DECISION DELEGATED TO HEAD OF PLANNING**DECISION DELEGATED TO HEAD OF PLANNING**

Application No: H16-0279-24 **Applicant:** Scenic Homes Ltd

Proposal: Residential development comprising 7 dwellings

Location: Land To South Of 199 Cradge Bank Spalding Lincolnshire

site layout
1 : 250 scale

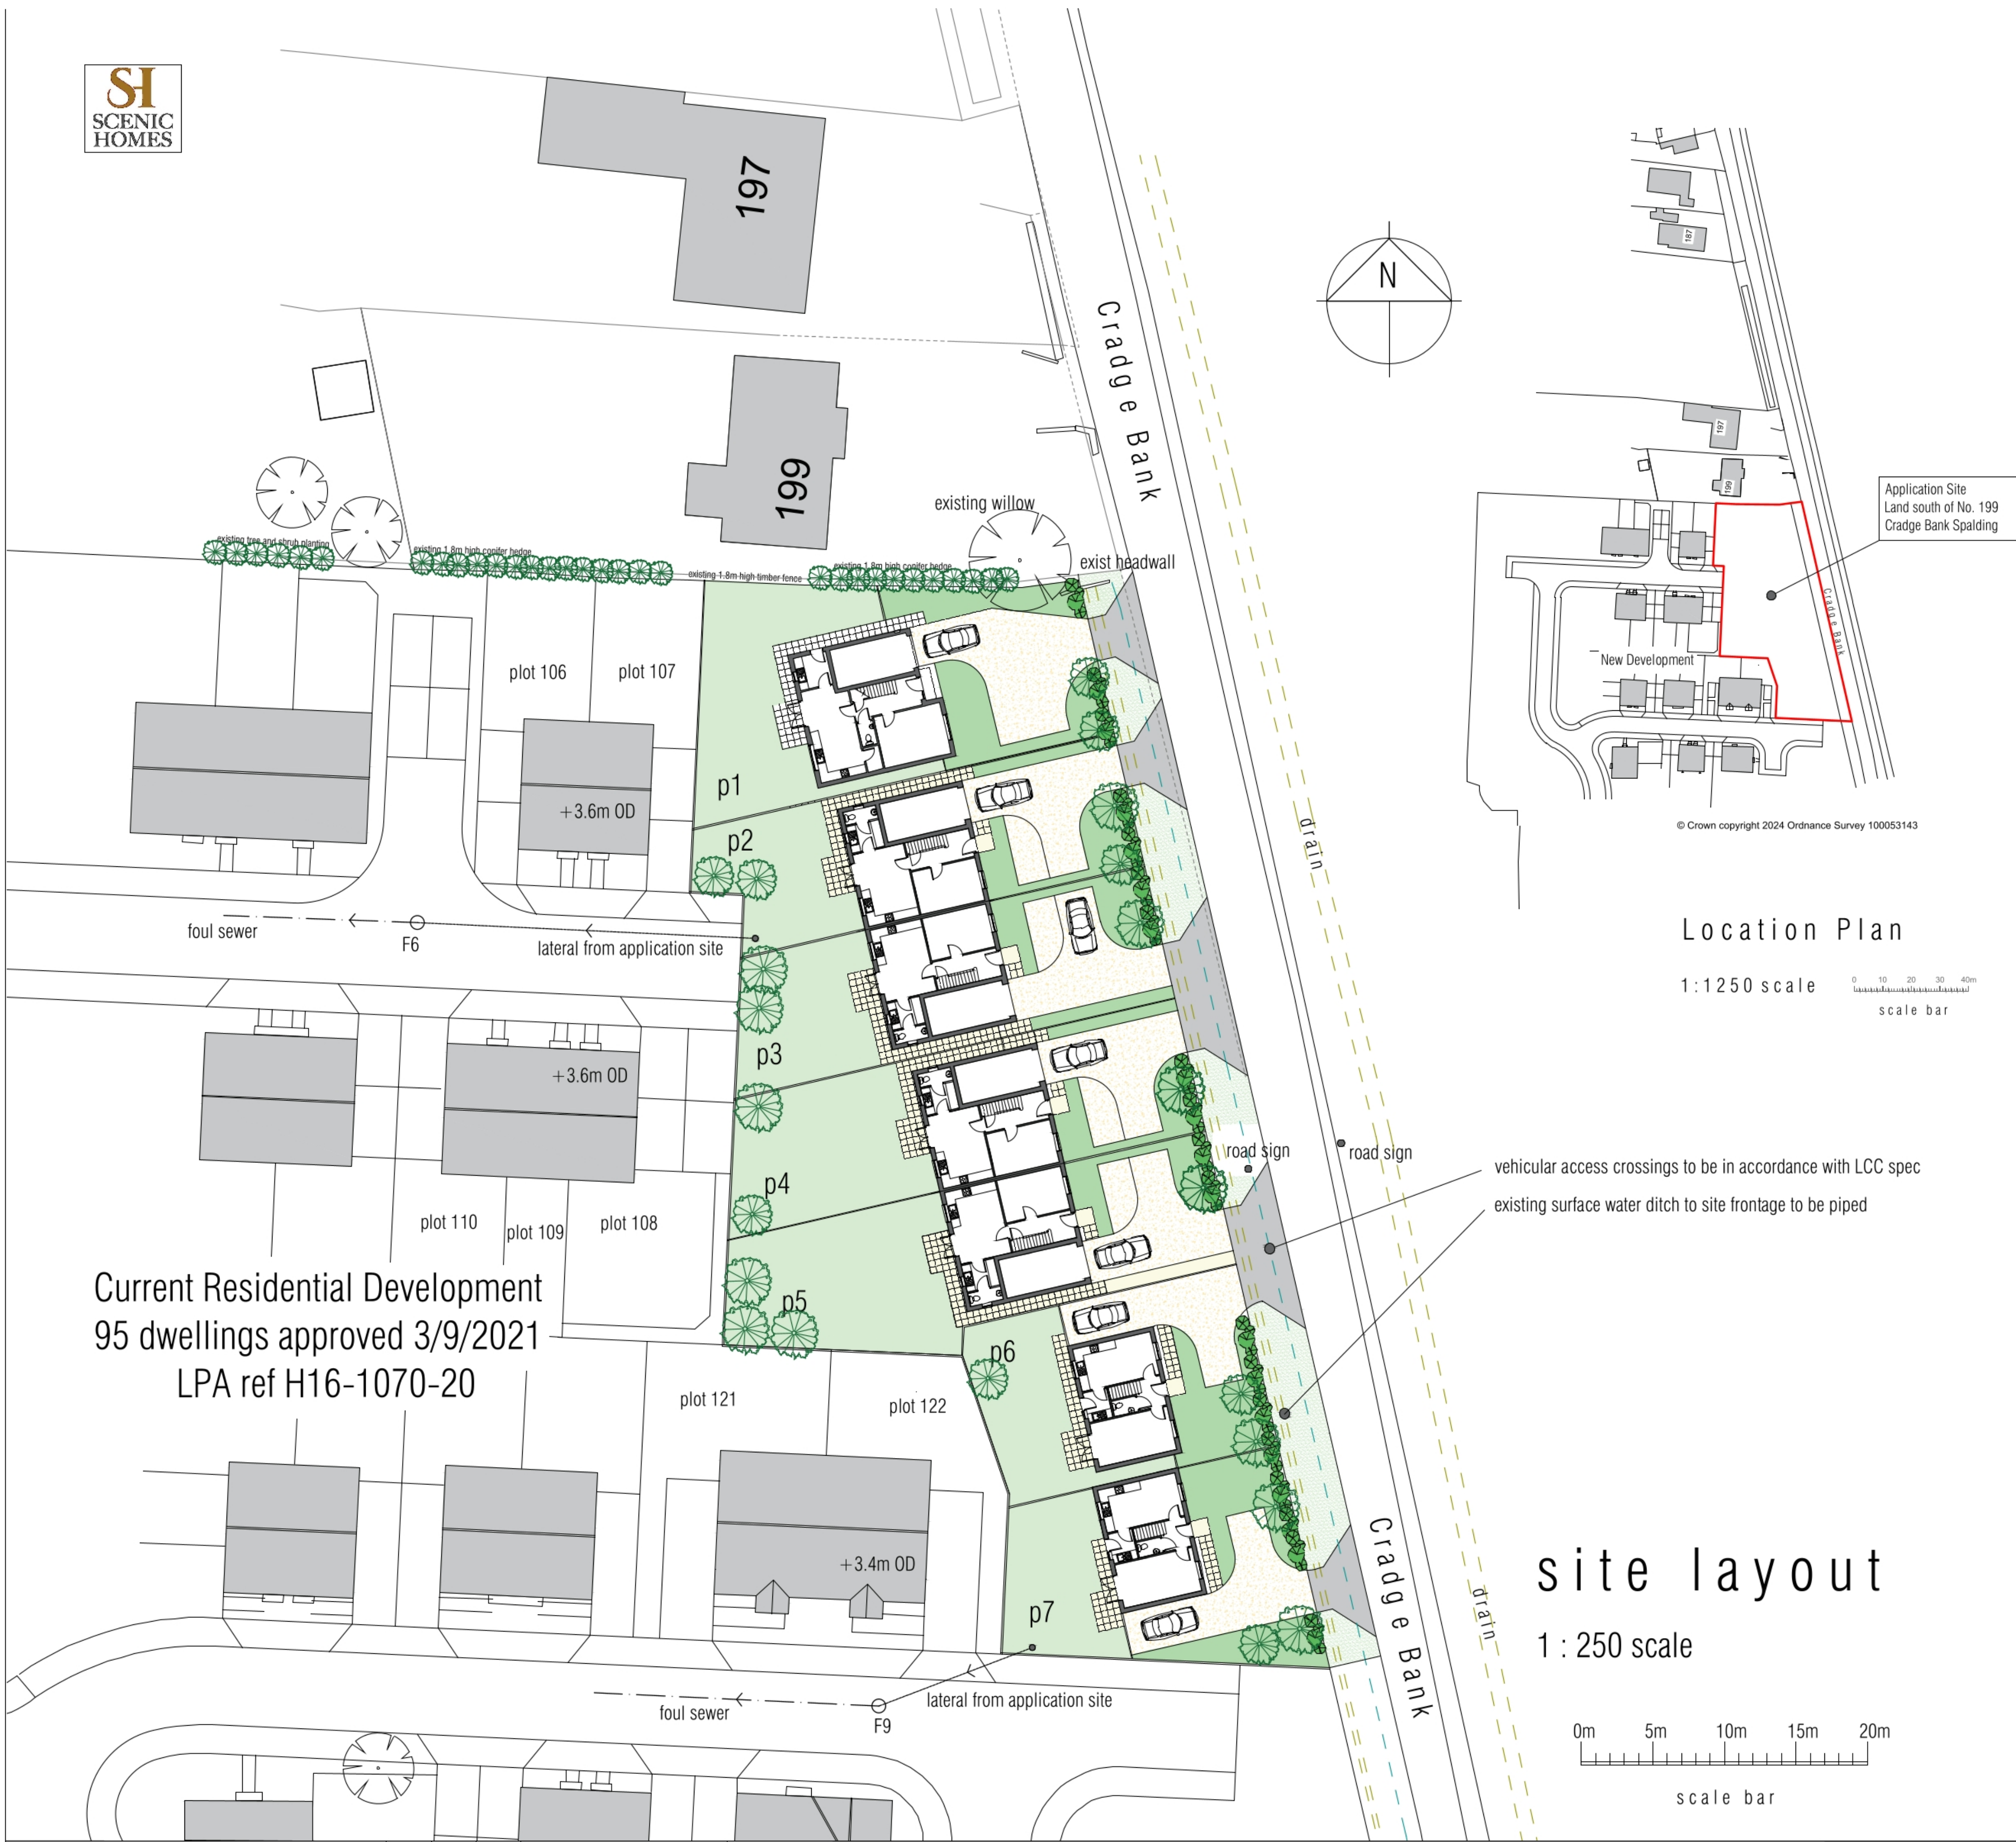
The layout and relationship of Plot 1 in relation to the adjoining residential property, number 199 Cradge Bank has been amended as it was previously a concern. Plot 1 at its closest point to the

flank boundary of 199 Cradge Bank is now 3.34 metres (as opposed to 1.98 metres originally) from the boundary, tapering out to 5.08 metres in from the boundary. Plot 1 is set 5.66 metres further forward than the front main wall of 199 Cradge Bank as amended - again, this distance has been reduced so that it is far less prominent than originally submitted. Now that Plot 1 has also been pulled back from the boundary, and been handed, the impact of the position and layout of this property is much improved, to the extent that it is not thought that the proposal is unacceptable in design terms. It's overall bulk has also been reduced. Overall in design and layout terms, the design, position and bulk of Plot 1 is considered acceptable in its amended form.

The parking associated with the 7 plots has been amended and is now arranged as follows in relation to bedrooms:

Plot 1 - 4 bedrooms - 3 spaces
Plot 2 - 4 bedrooms - 3 spaces
Plot 3 - 4 bedrooms - 3 spaces
Plot 4 - 4 bedrooms - 3 spaces

Plot 5 - 4 bedrooms - 3 spaces
Plot 6 - 3 bedrooms - 2 spaces
Plot 7 - 3 bedrooms - 2 spaces

Whilst Plots 1 to 5 have internal garages, these are not of an internal size to count as garages according to the Local Highway Authority since they are less readily usable for modern cars. However, the amended plans have increased the size of forecourt parking for each dwelling. The amended plans now show that Plots 1 to 5 have sufficient car parking in comparison with bedroom sizes to conform with Annex 6 and Policy 36 of the SELLP which requires three parking spaces for dwellings with more than four bedrooms. The parking arrangements for plots 1 to 5 are therefore satisfactory. Parking for plots 6 and 7 were compliant at the time of submission. Plots 1 to 5 can accommodate cycles within the garages and therefore comply with minimum cycle parking levels. Plots 6 and 7 can have a condition attached to include a wall mounted cycle parking rack. It is therefore considered that in parking terms the proposal complies with Annex 6 and Policy 36 of the SELLP.

date March 2024
scale(s) 1:100 @A3
DRG. No. Sce/CrB/ pl / P1/Elev revA

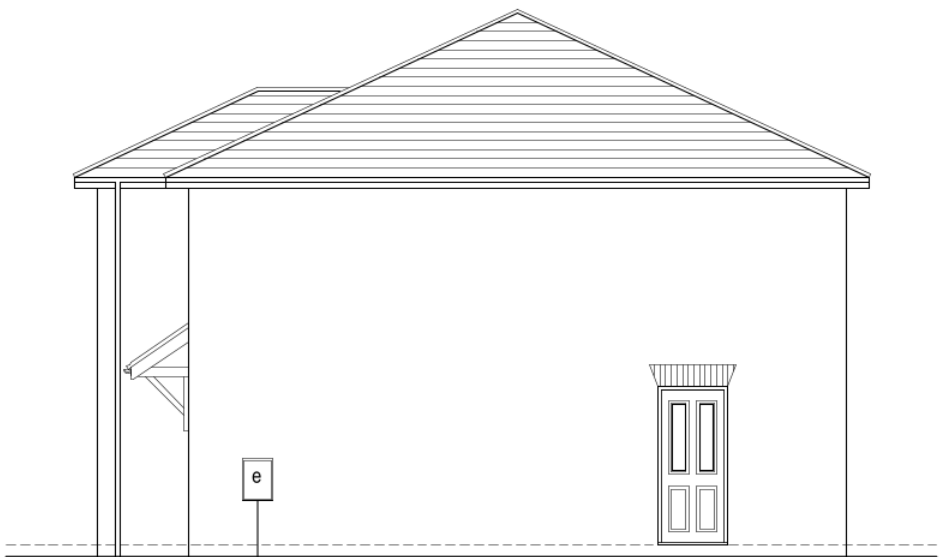
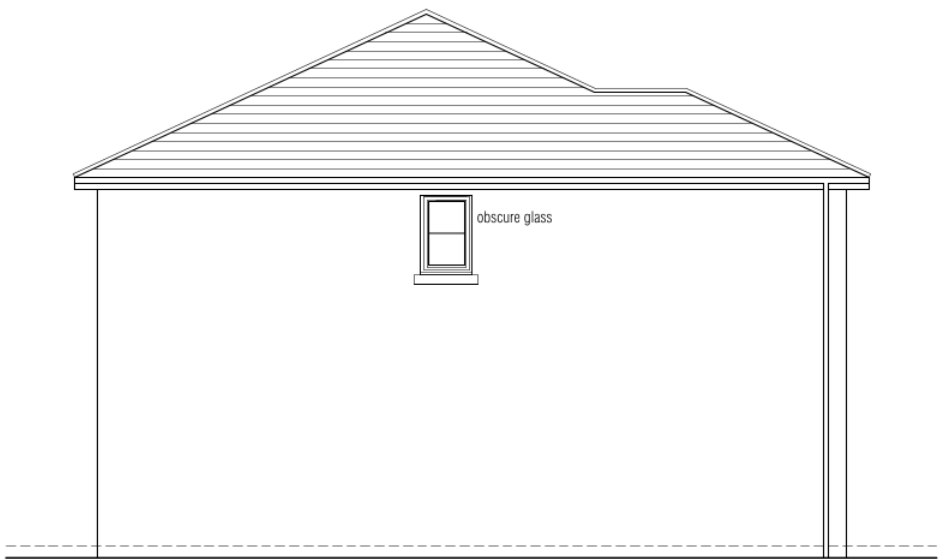
Plot 1 is a four bedroom dwelling with integral garage. It is 8.7m long on the northern flank and 9.9m long on the southern flank, and is 9.5m wide. It is 4.86m to the top of the eaves, and 7.2m to the top of the ridge. The height has been specifically reduced to minimise the impact upon the neighbour. The roof design has been changed to a hipped roof to also reduce the overall bulk of the property.

-Height to top of ridge: 7.22m
-Height to eaves level: 4.86m

A street scene/cross section has been submitted which illustrates the finished floor levels, eaves and ridge height of Plot 1 in relation to 199 Cradge Bank. This shows that the eaves are to be 8.1m, and the ridge height is 10.4m. This is only marginally higher than 199 Cradge Bank which has an eaves level of 7.21m and a ridge height of 9.82m.

The amended height of Plot 1, now set further away from the boundary, with an amended roof design, means that the proposals will not lead to a significant loss of view and a feeling of enclosure, thereby adversely affecting residential amenity. It is not therefore considered contrary to both policies 2 and 3 of the SELLP.

Rev A - may 24 - handed design to plot 1

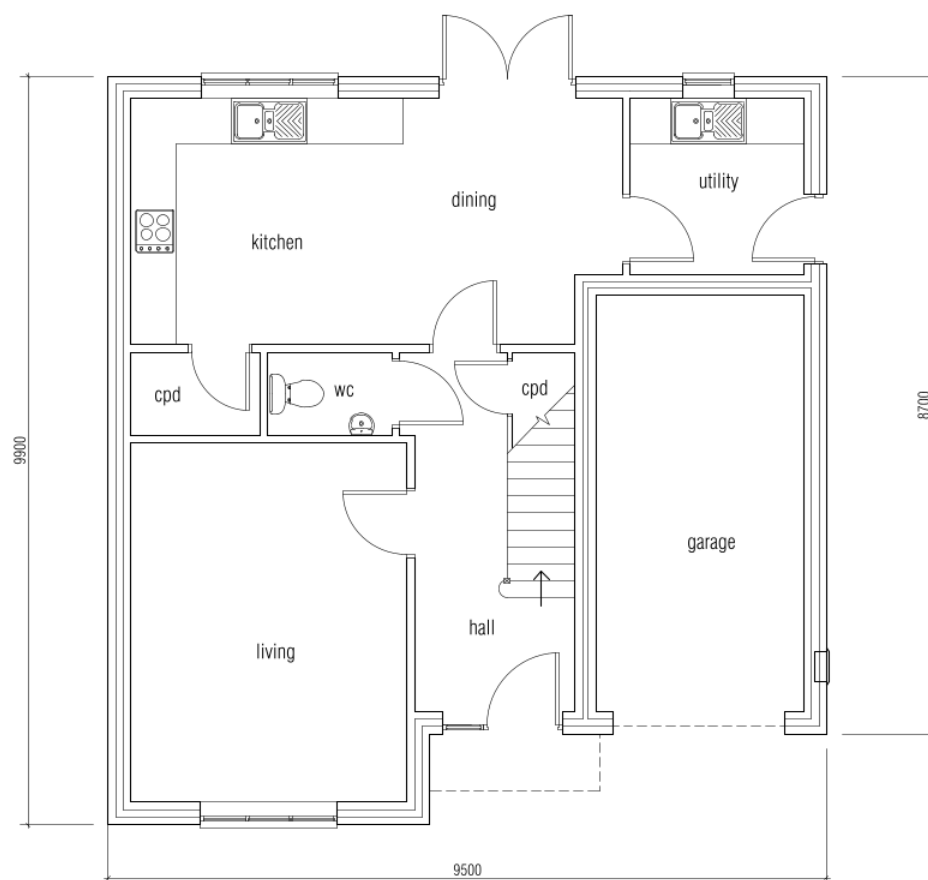
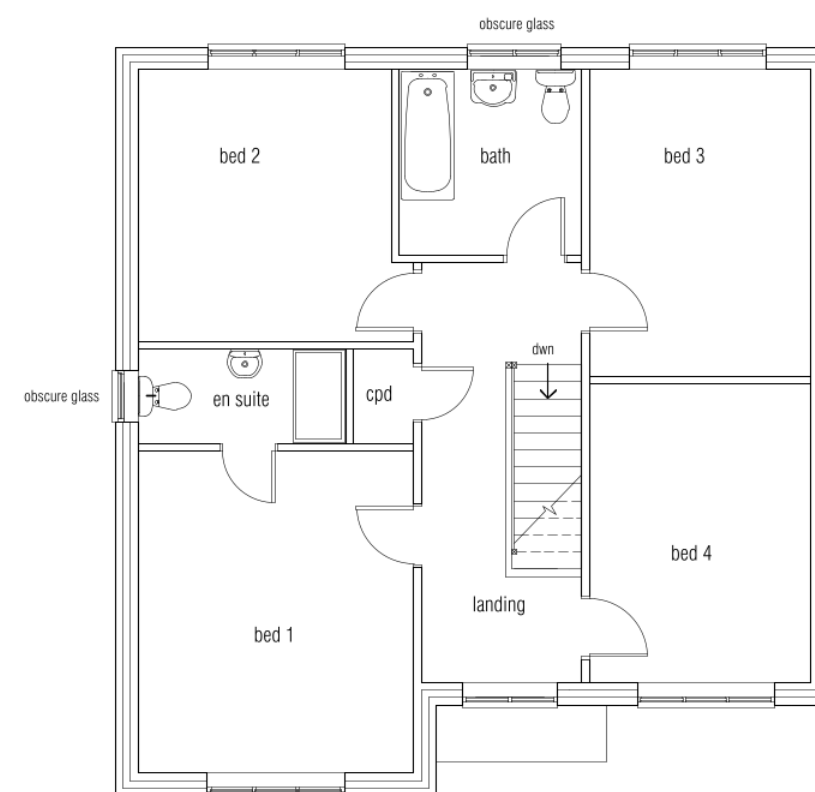
The internal garage is 2.74m wide internally and 5.5m long internally with the opening being 2.3m. It has a rear amenity area of between 6.1m and 8.6m (the plot is set at an angle). It is set 5.7m forward of the boundary of number 199 Cradge Bank, which is set 2.15m in from its boundary. Plot 1 is at an angle, with the closest edge to the neighbour being at the front, set in 3.24m in from the boundary. At the rear it is 5.08m in from the boundary. The amended floor plan has been handed so the garage faces the neighbour, and is shorter.

front elevation - plots 2 & 3, 4 & 5

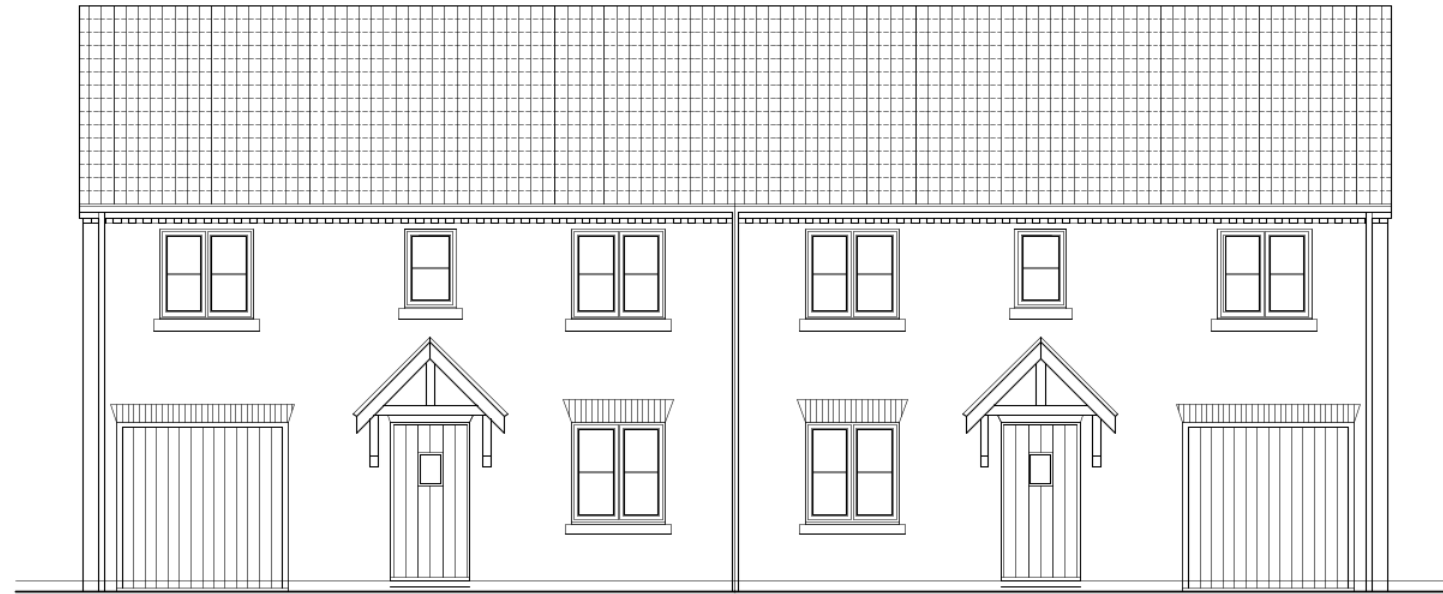
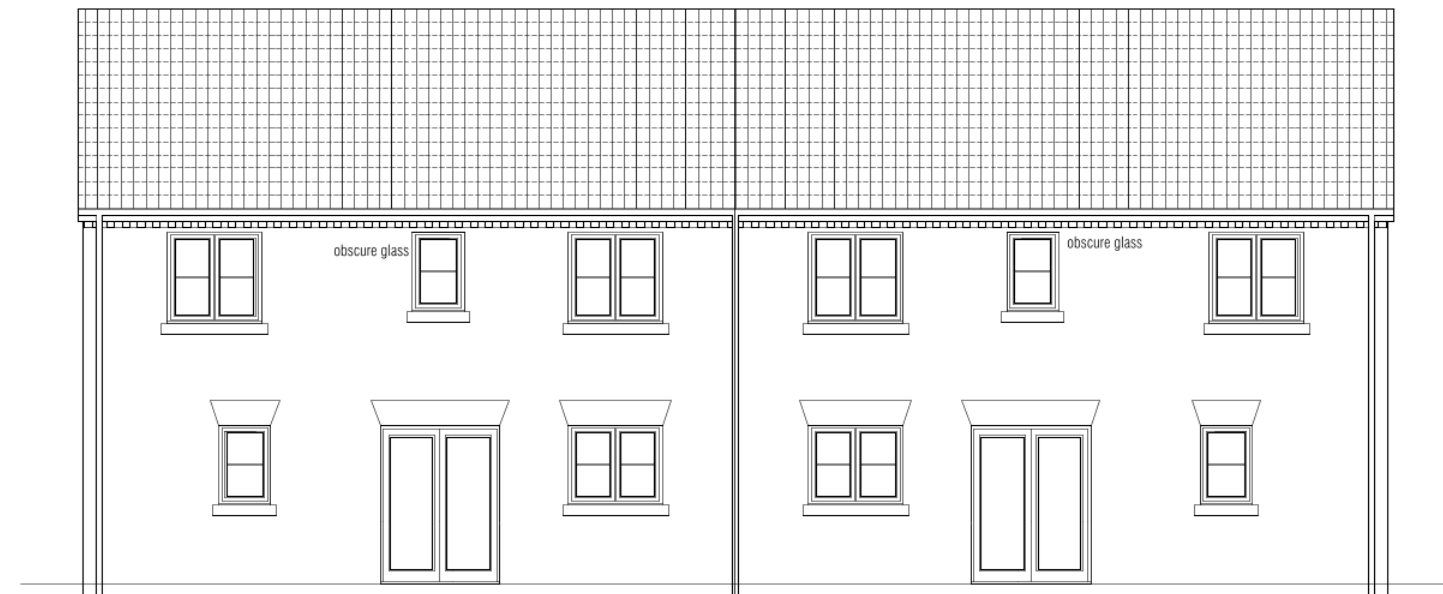
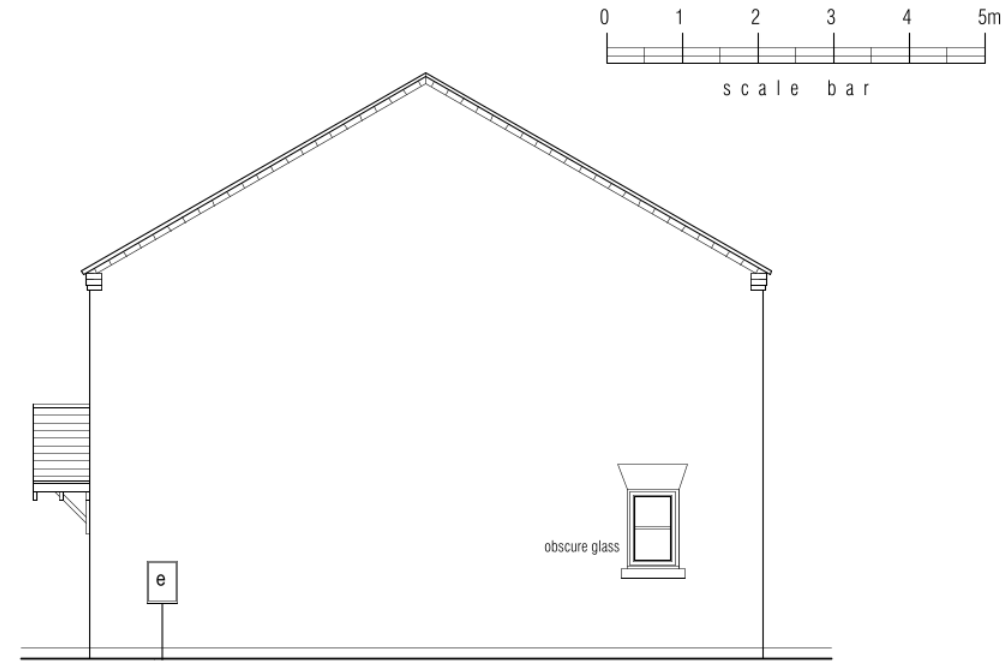
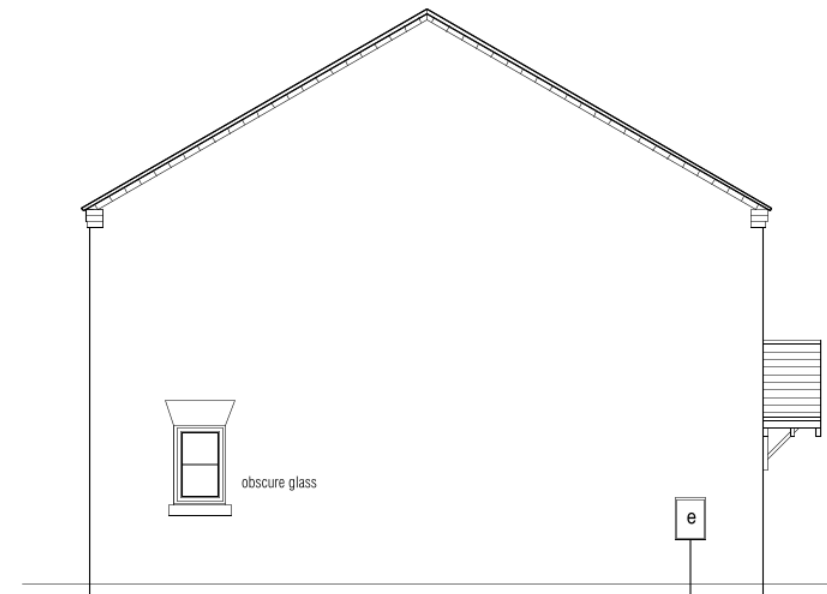
Plots 2, 3, 4 and 5 are 4 bedroomed semi detached pairs which are 8.9m long and the two pairs are 17.4m wide. They have internal garages which are 2.84m wide and 5.53m long with an opening of 2.25m wide. The driveways have the capacity to accommodate 3 car parking spaces on the amended front drives.
